# CITY OF ALBUQUERQUE

May 12, 2025

**RE: North Domingo Baca Aquatic Center  
Grading & Drainage Plan & LOMR  
Engineer's Stamp Date: 9/18/2023  
Hydrology File: C18D043E  
Case # HYDR-2025-00013**

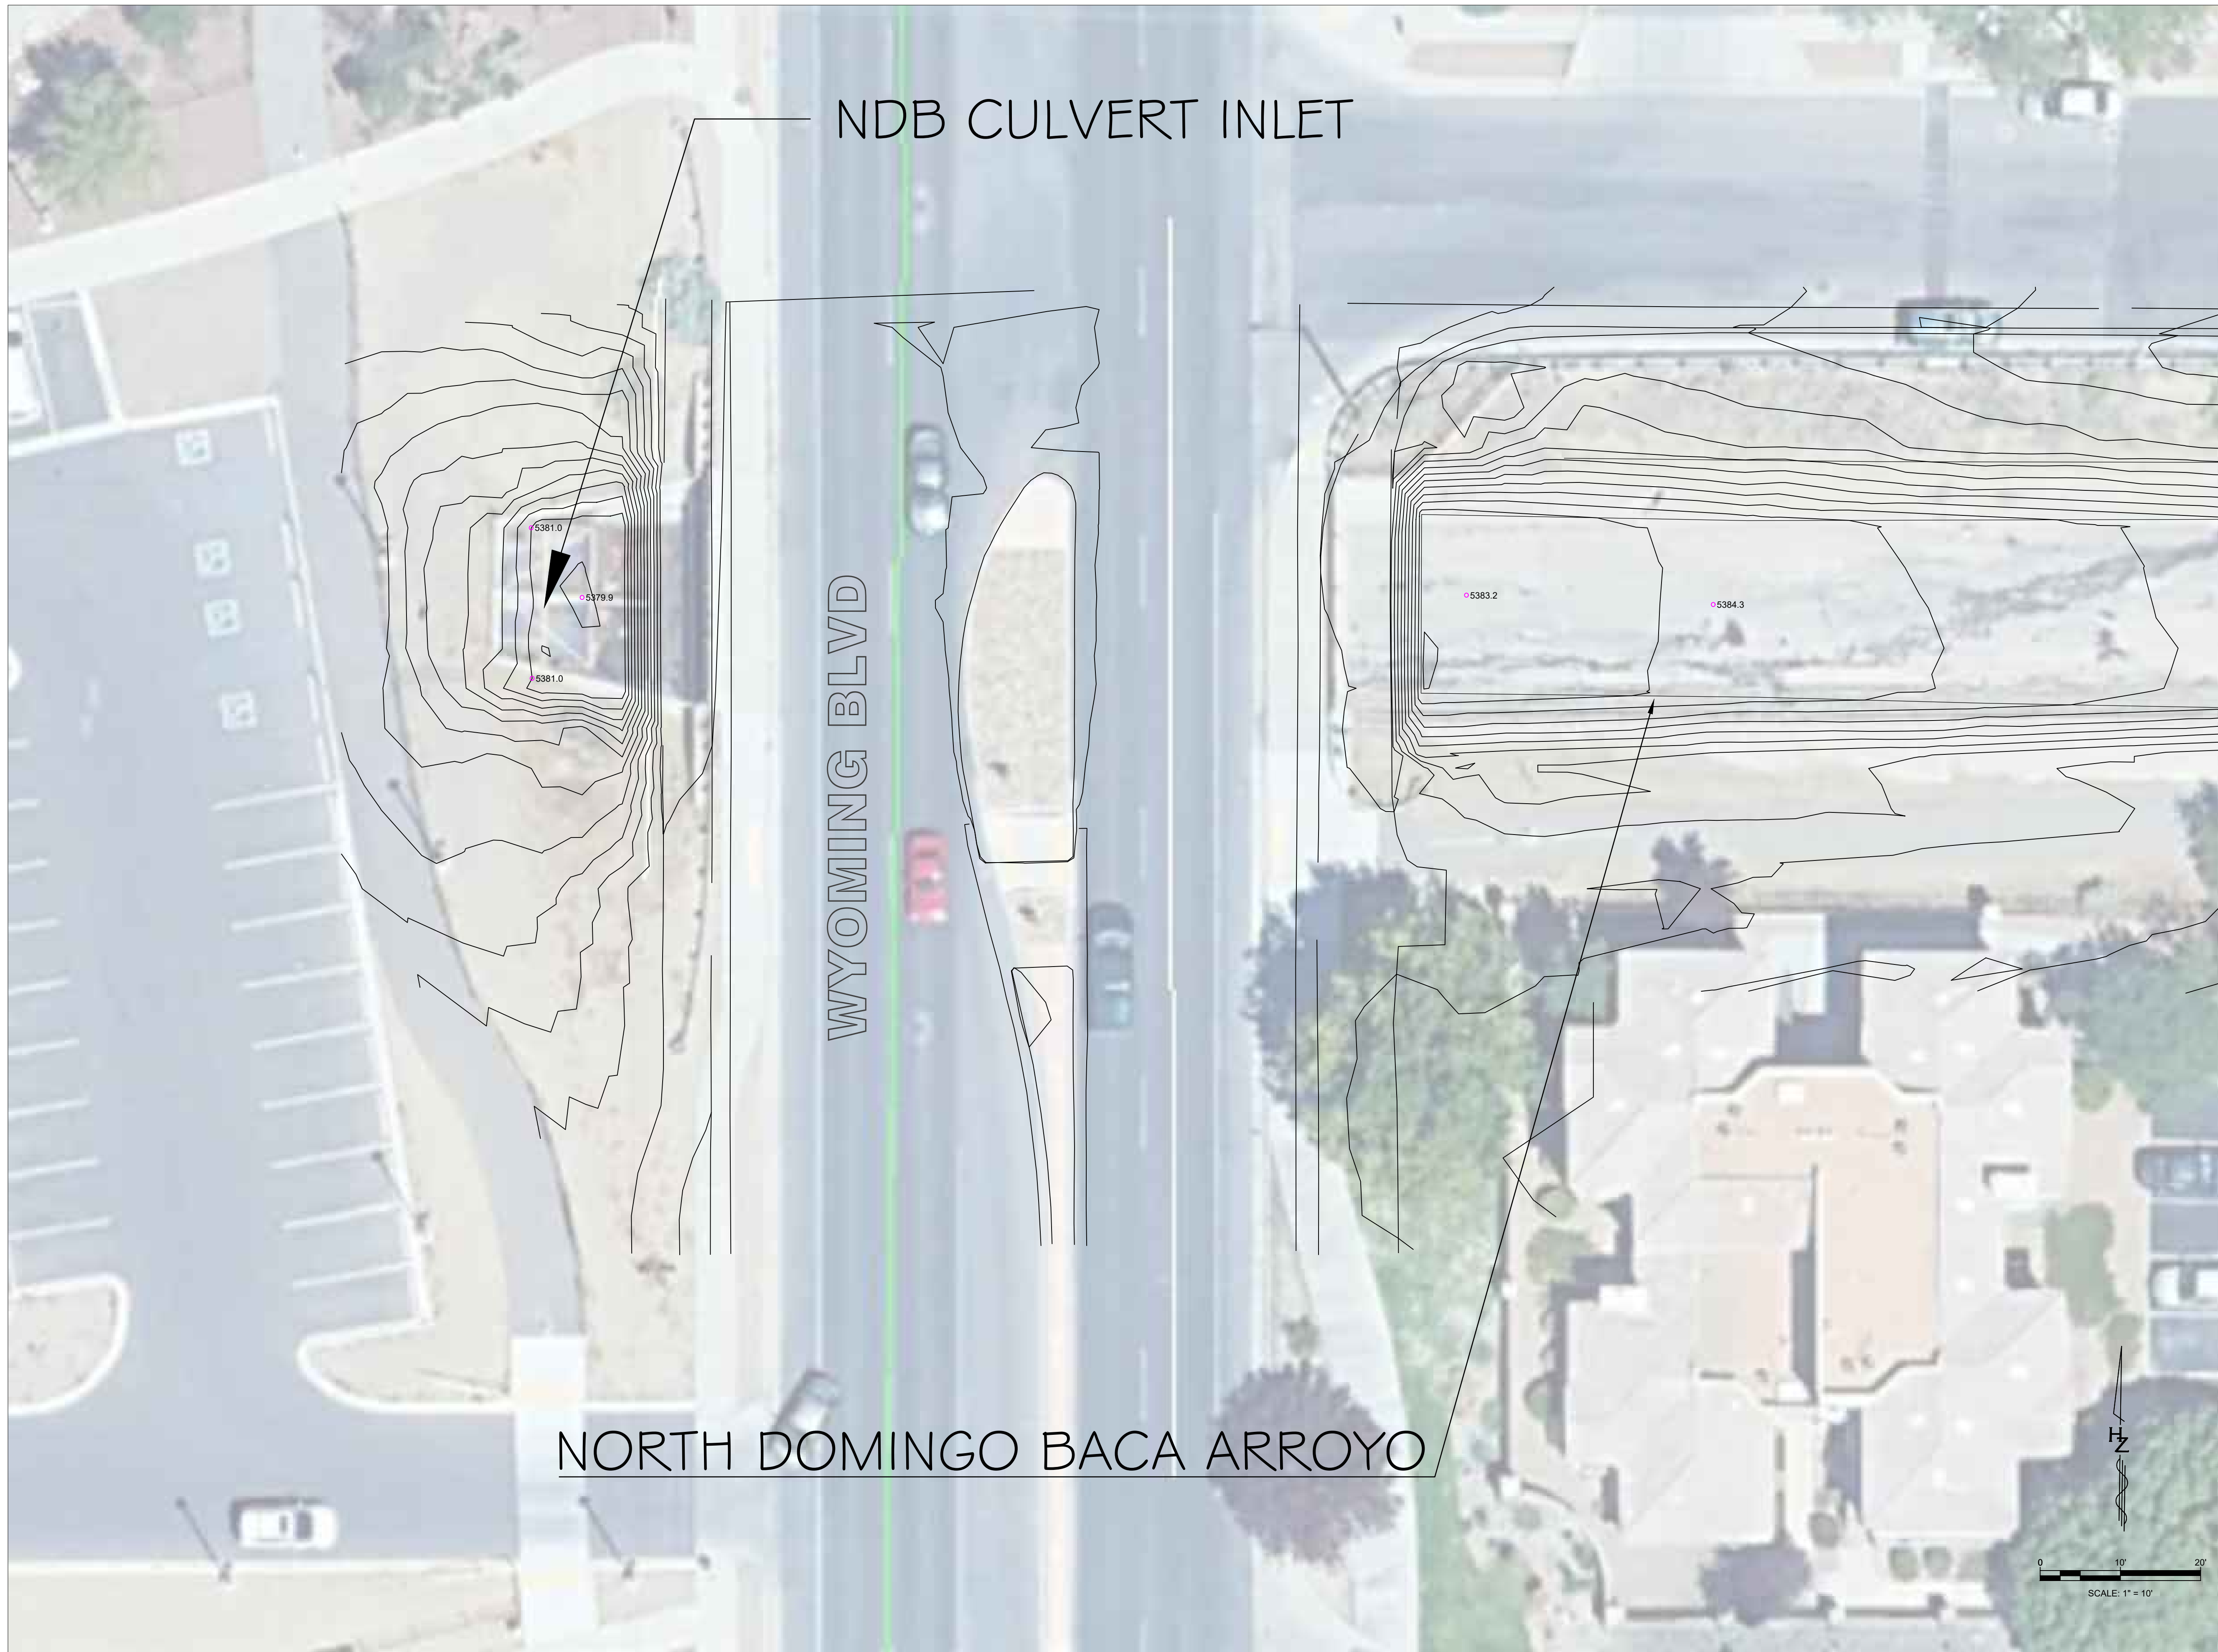
1. LOMR Pg 7 of 39 – B. 1. Line 1 & 2 – The Community Number is 350002. Please correct on both locations.
